CITY OF ALBUQUERQUE

Re: Discount Towing, 109 Headingly Ave. NW
Request for Certificate of Occupancy- Transportation Development
Architect's Stamp dated 4-7-16 (G15D201)
Certification dated 10-18-16

C1.1

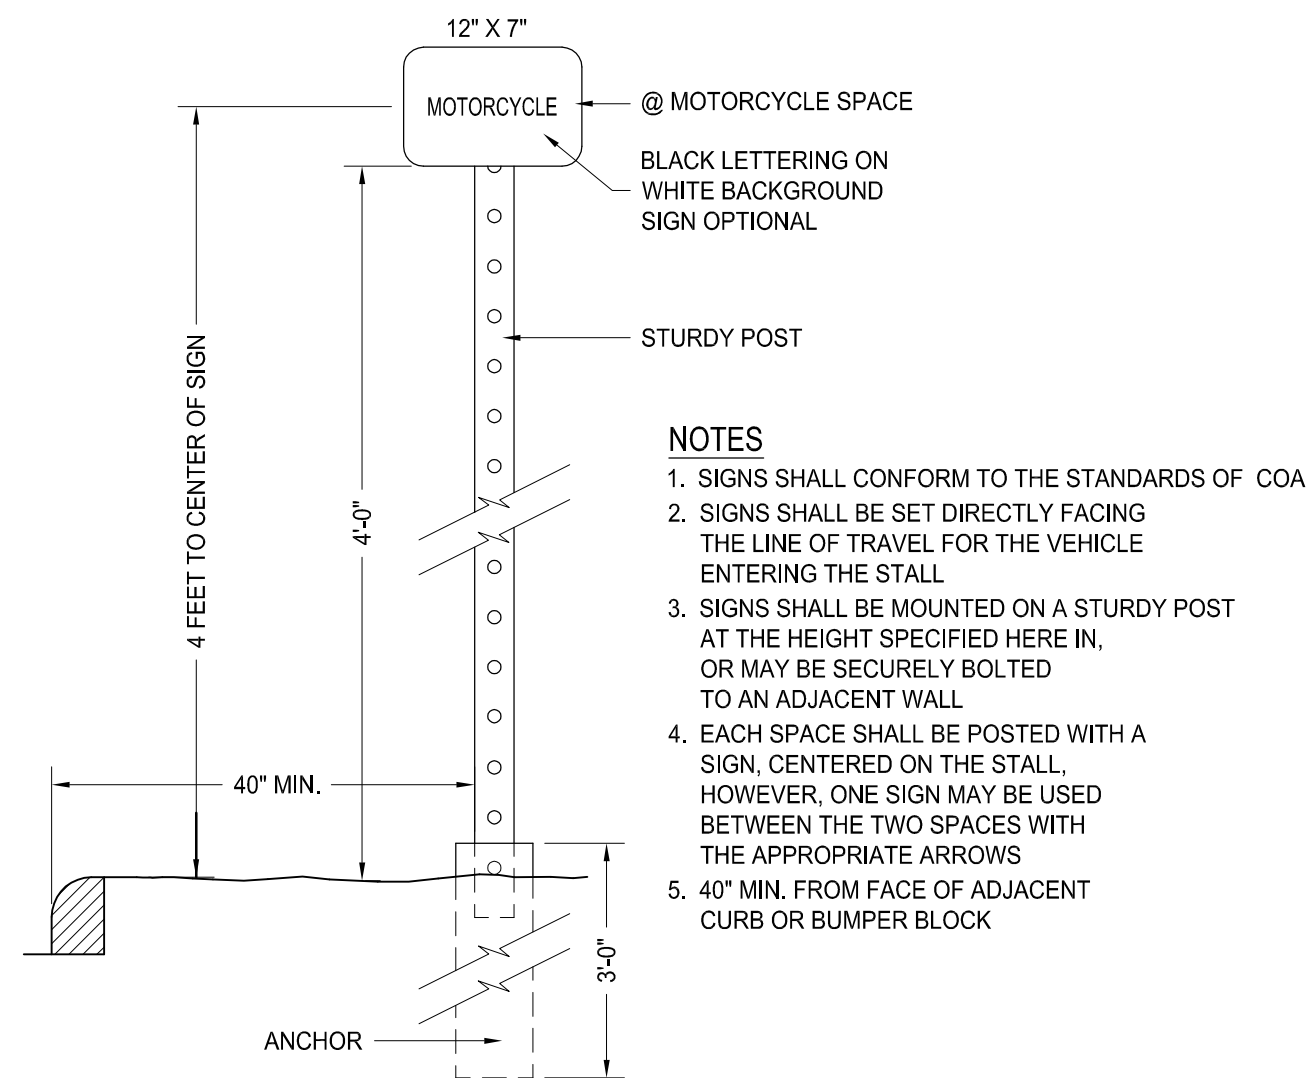
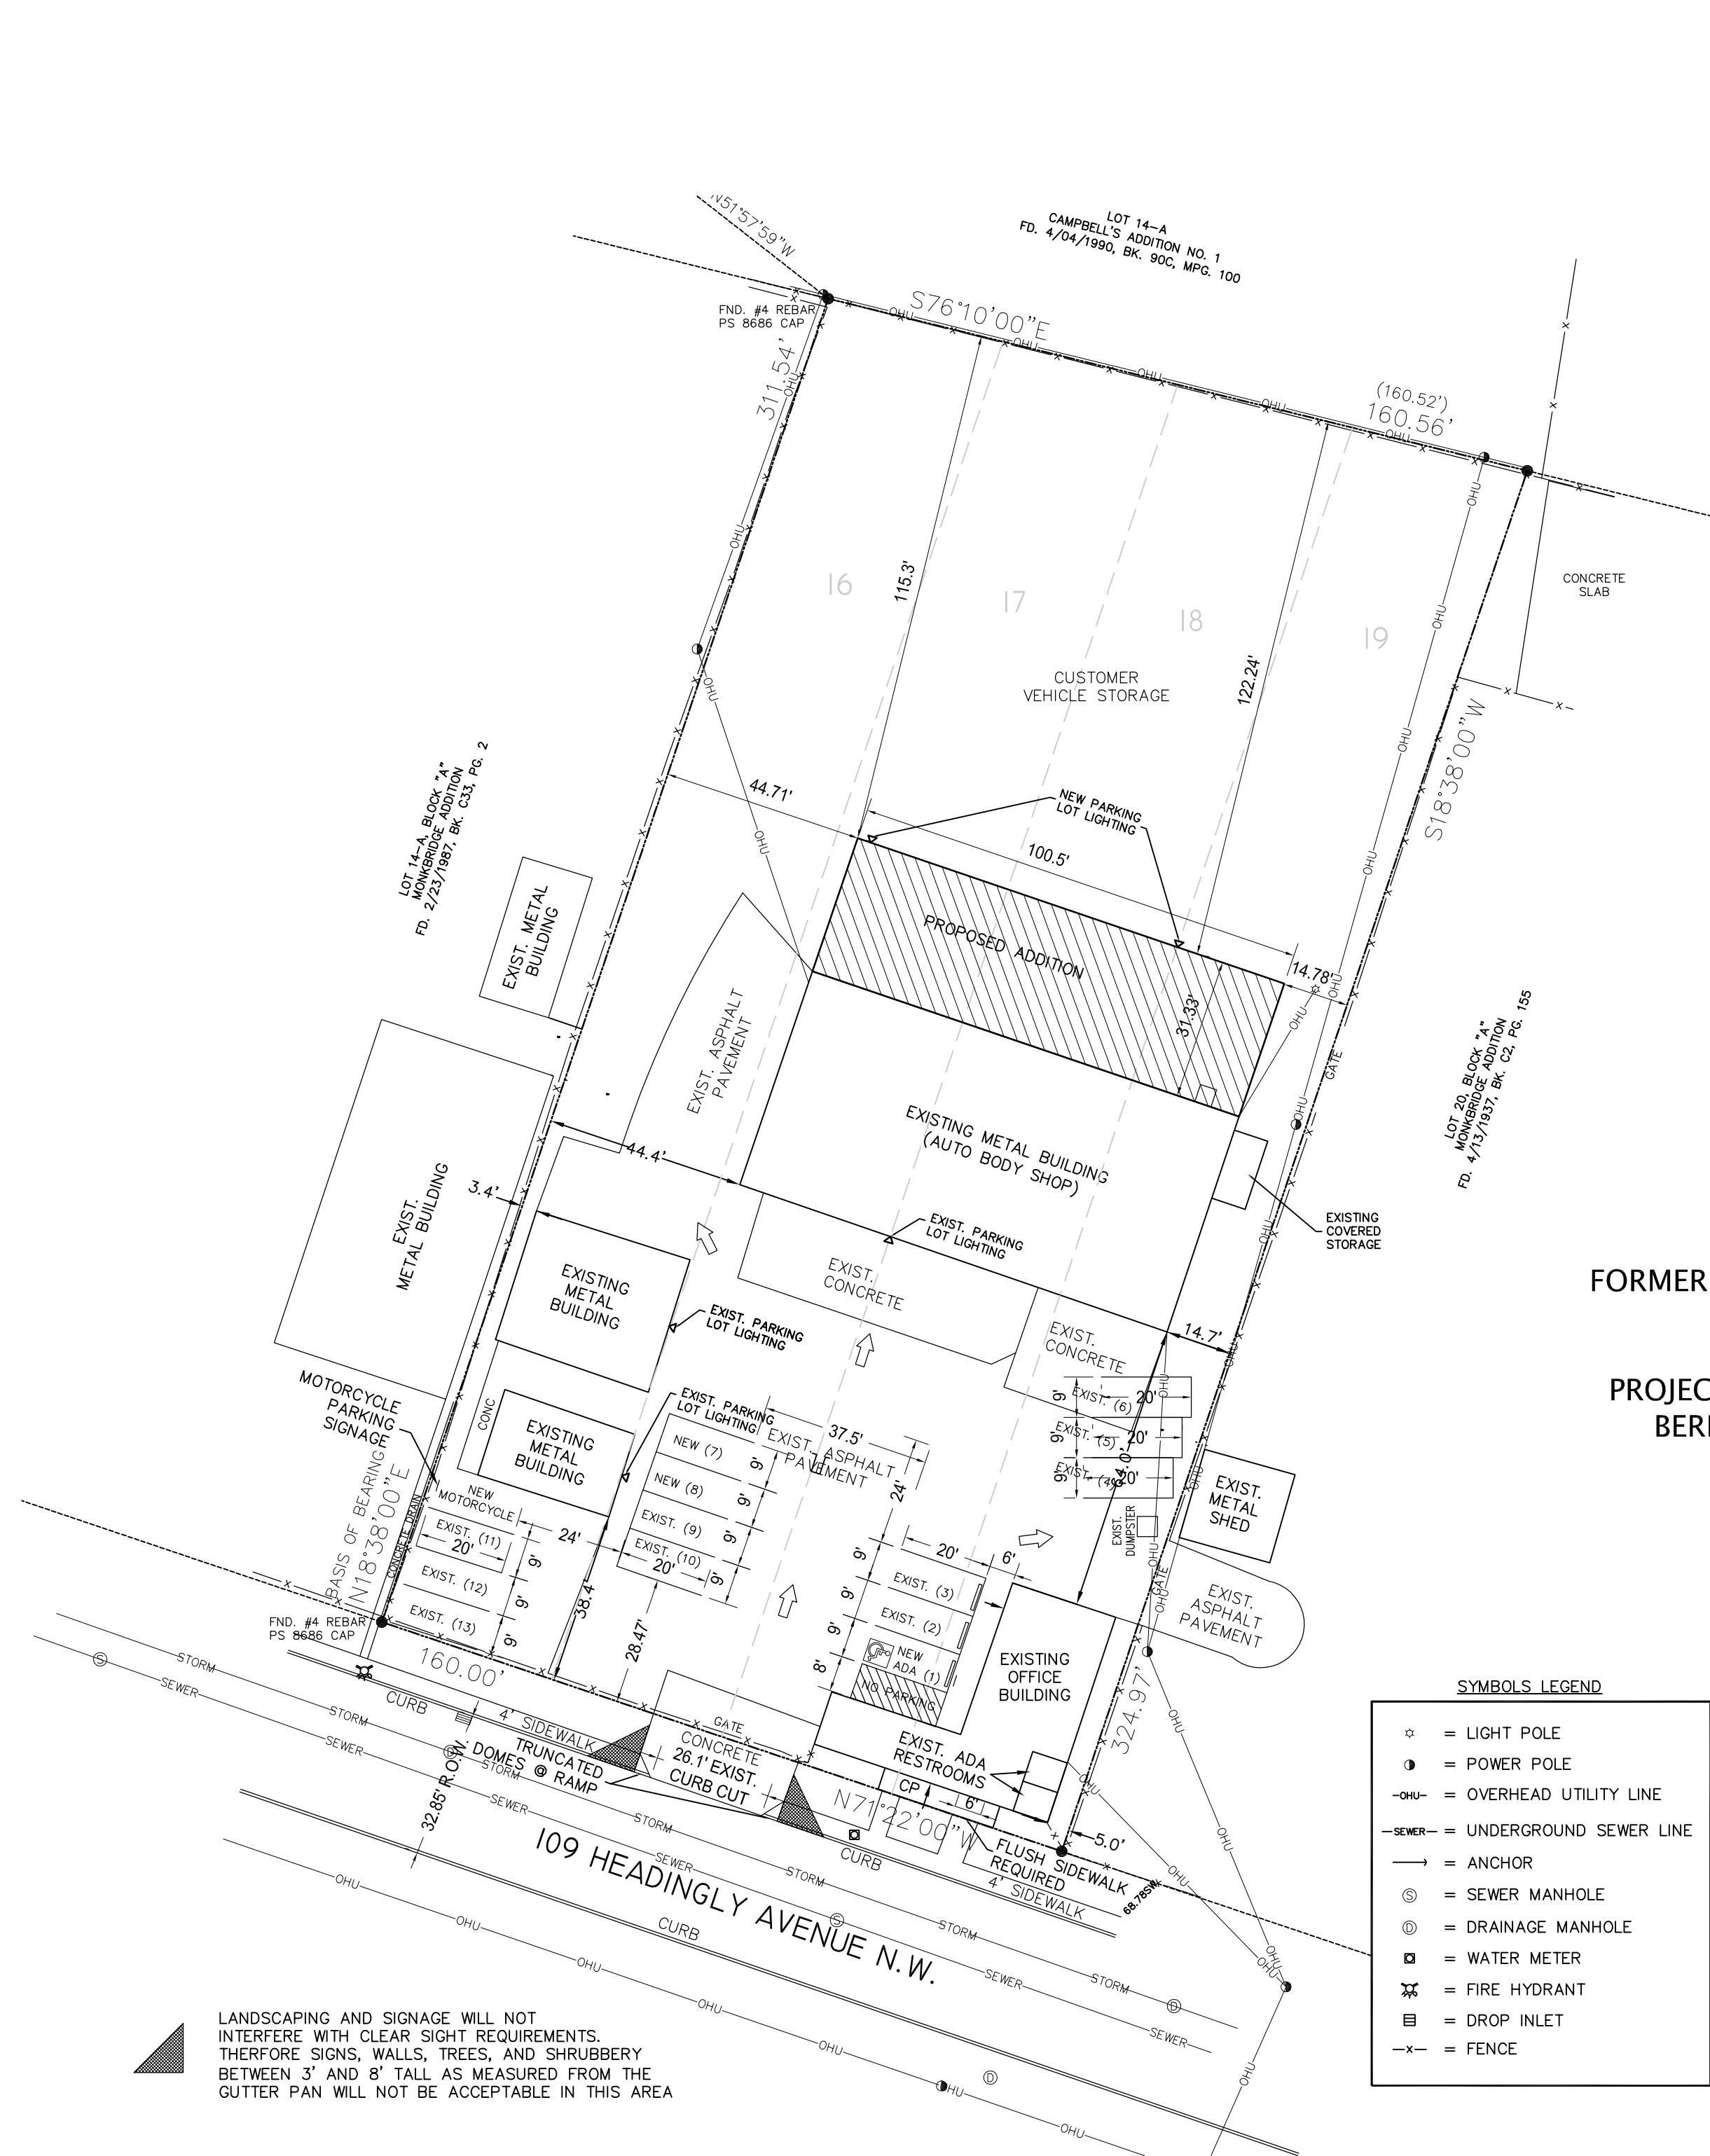
- The proposed parking area improvements have not been constructed per plan.
- The ADA accessible parking sign must have the required language per 66-7-352.4C NMSA 1978 "Violators Are Subject to a Fine and/or Towing." Please call out detail and location of HC signs.
- The ADA access aisles shall have the words "NO PARKING" in capital letters, each of which shall be at least one foot high and at least two inches wide, placed at the rear of the parking space so as to be close to where an adjacent vehicle's rear tire would be placed. (66-1-4.1.B NMSA 1978)
- Van accessible spaces bottom of this sign 60" min. above the ground. ANSI 502.7
- Please correct the traffic certification letter for your project inspection date.
